A/149/20/L

6 Longback Cottages Arundel Road ANGMERING BN16 4JT

Part two storey part single storey rear extension

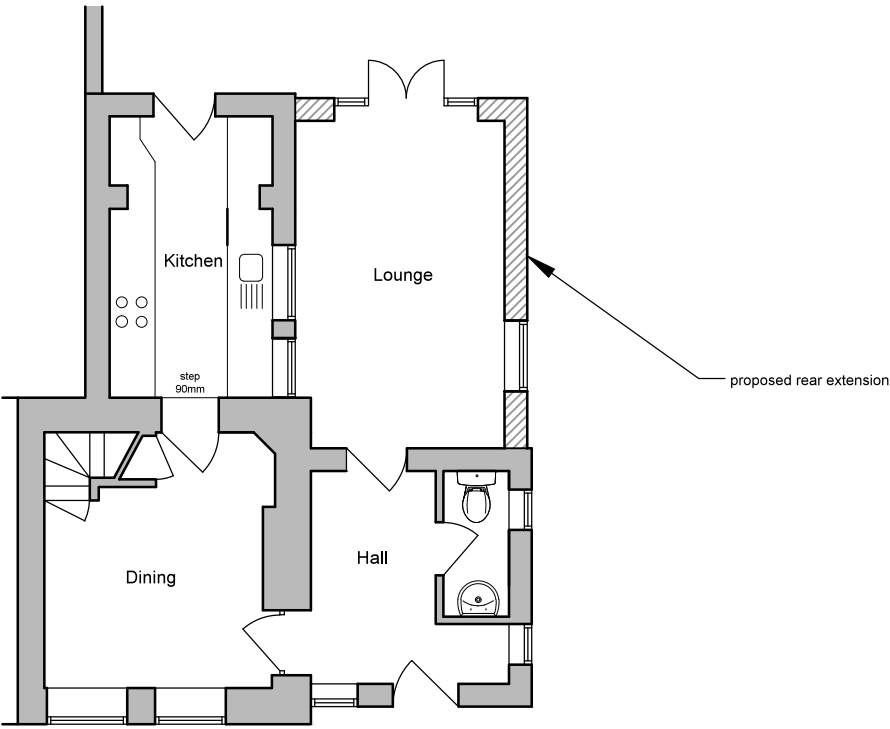
The proposal is for an extension to one of the end of terrace properties. It would appear that the property has already been altered and extended, and the proposal would be located behind a small-scale single storey side extension. Such a proposal represents a large extension in the context of the very modest residential cottage, especially when viewed from the north and west and would be out of character. Further, it is thought that the extension could be partly viewed from the road when travelling into the village, and therefore visible to the conservation area.

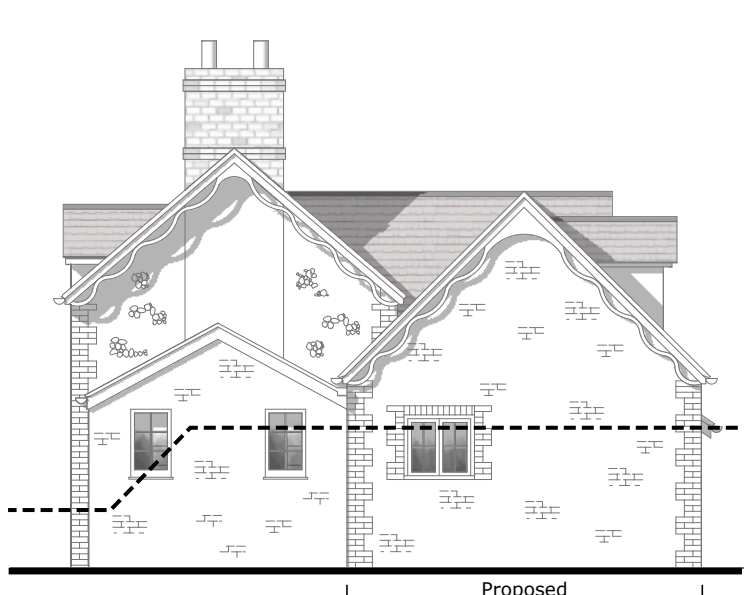
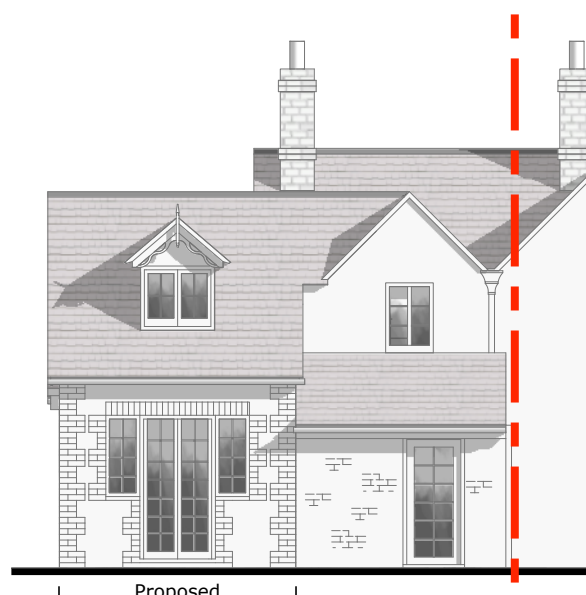
It is noted that the intention is to use materials appropriate for the building so as to ensure that it is of suitable appearance. Such an approach is supported, subject to them being provided to the council by way of condition.
